Our Ref: BR/140/18/PDH

Description	Notification under extended permitted development rights for a single storey rear extension from the original rear wall by 7m with a maximum height of 4m and an eaves height of 3m.
Location	60 Chichester Road Bognor Regis,,

BLOCK PLAN
AREA 90m x 90m
SCALE 1:500 on A4
CENTRE COORDINATES: 493327, 100157

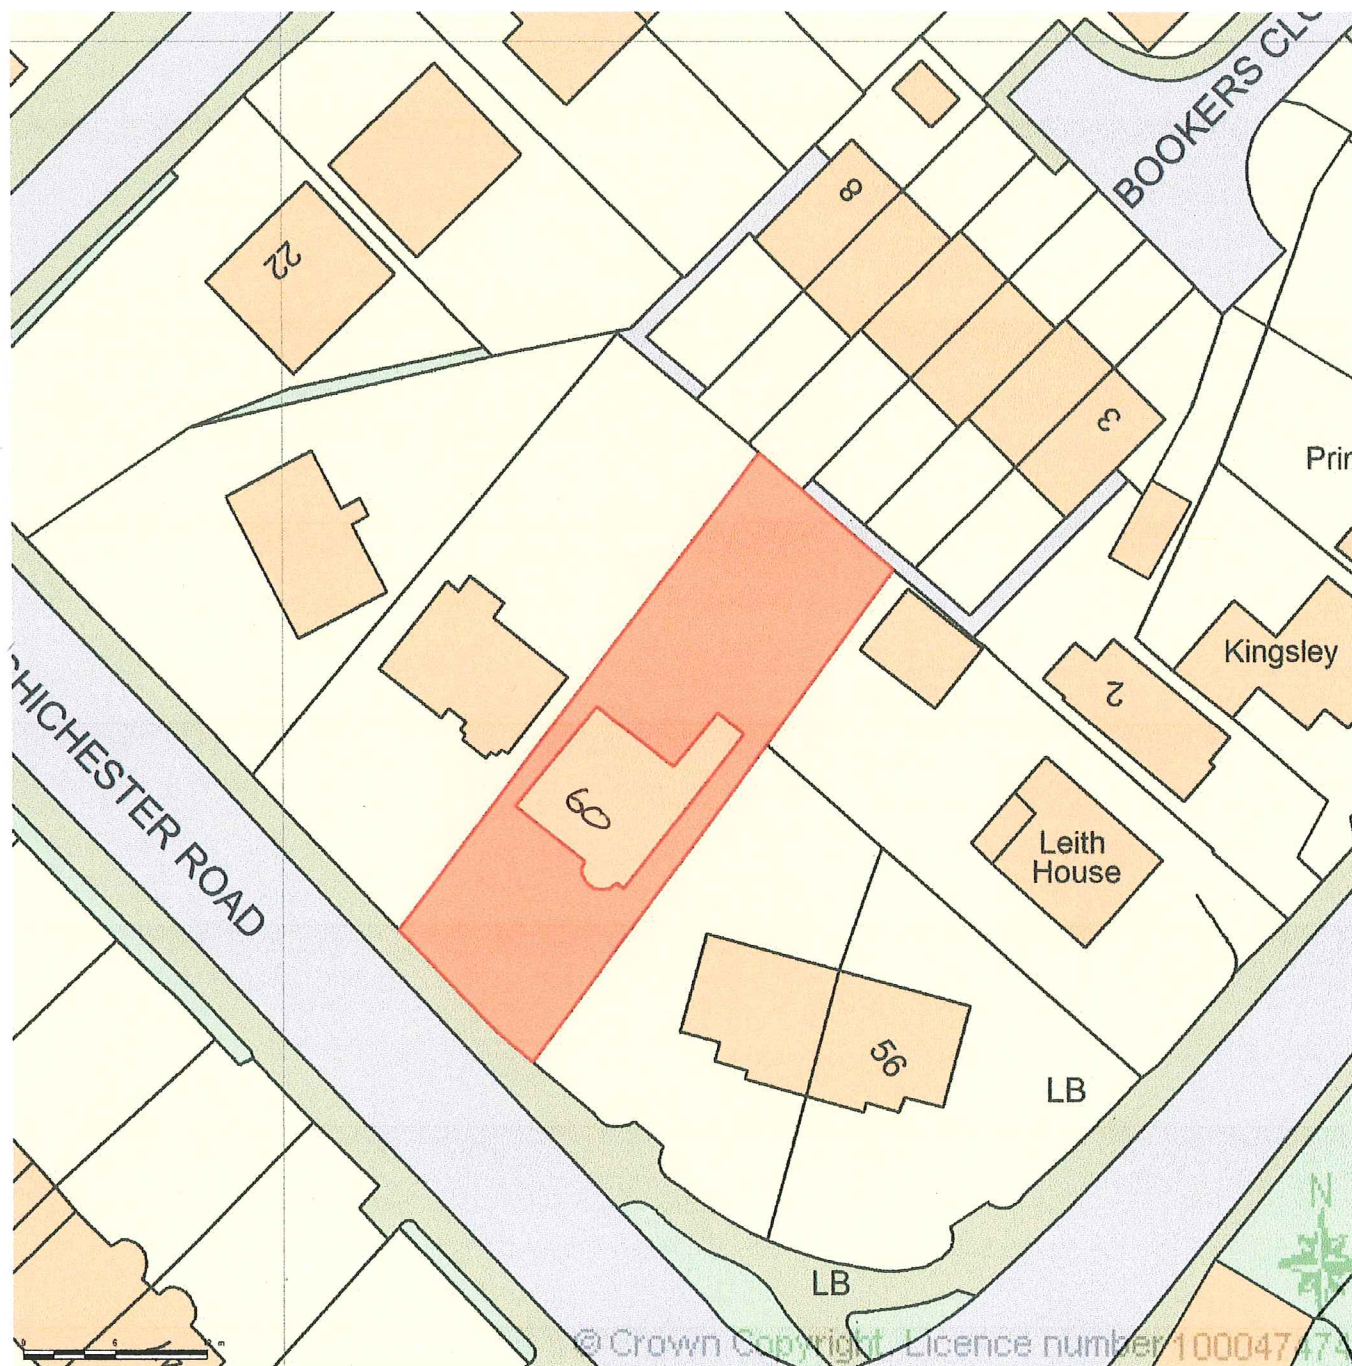
To avoid another refusal of this Prior Notification, please submit amended proposed plan with the extension no wider than the original part of the dwelling (i.e the new extension must be in line with the dining room and not include the extra 645mm of the kitchen).
